SUBJECT: **SFD2505-0011**
SINGLE FAMILY DWELLING

Here are the results of all Inspections located at **67 FERN RDG:**

Inspection Type: MONO SLAB
Scheduled Date/Time: 7/22/2025
Completed Date/Time: 7/22/2025
Inspector: Ricardo D Honrada
Result: DISAPPROVED
Remarks: eTRAKiT Inspection Request
Notes: 7/16/2025 5:10 PM Glenwood Homes

MONOLITHIC SLAB FOUNDATION PLAN
ELEVATION 2

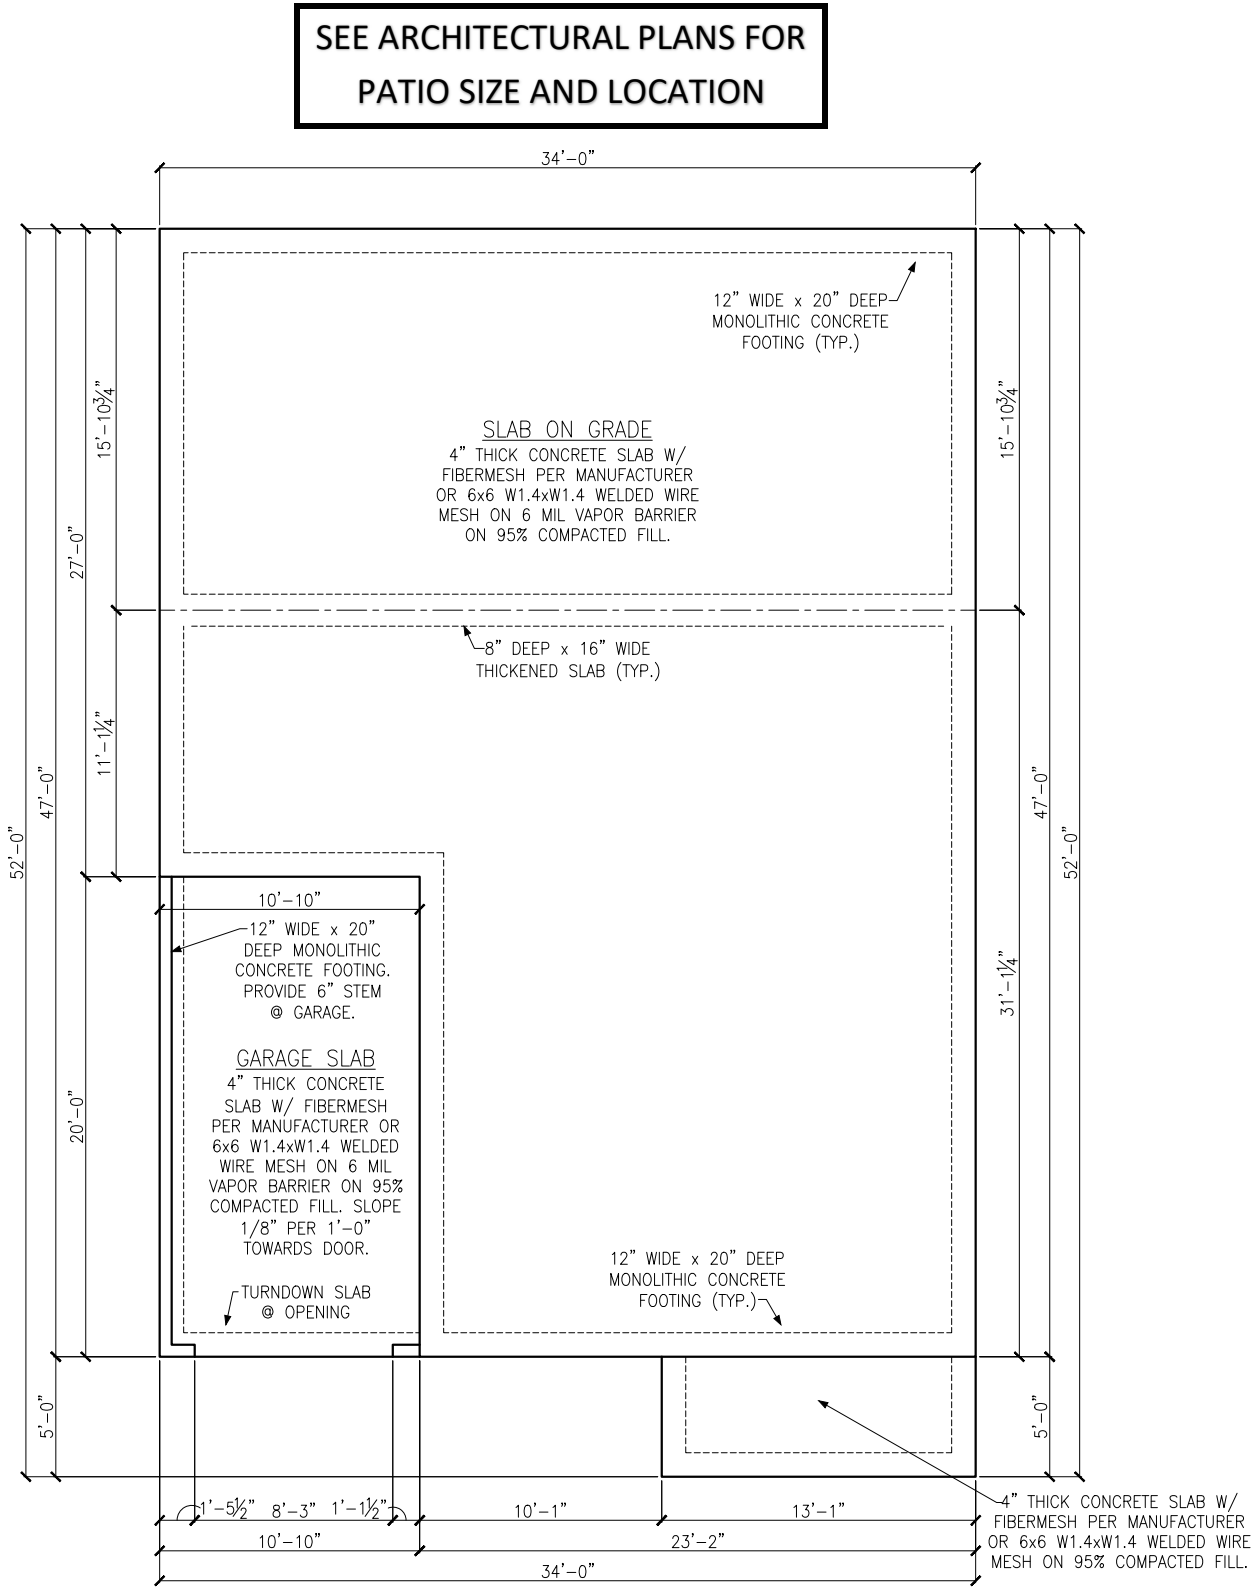
Wall footings in garage 20 inches deep as per plan
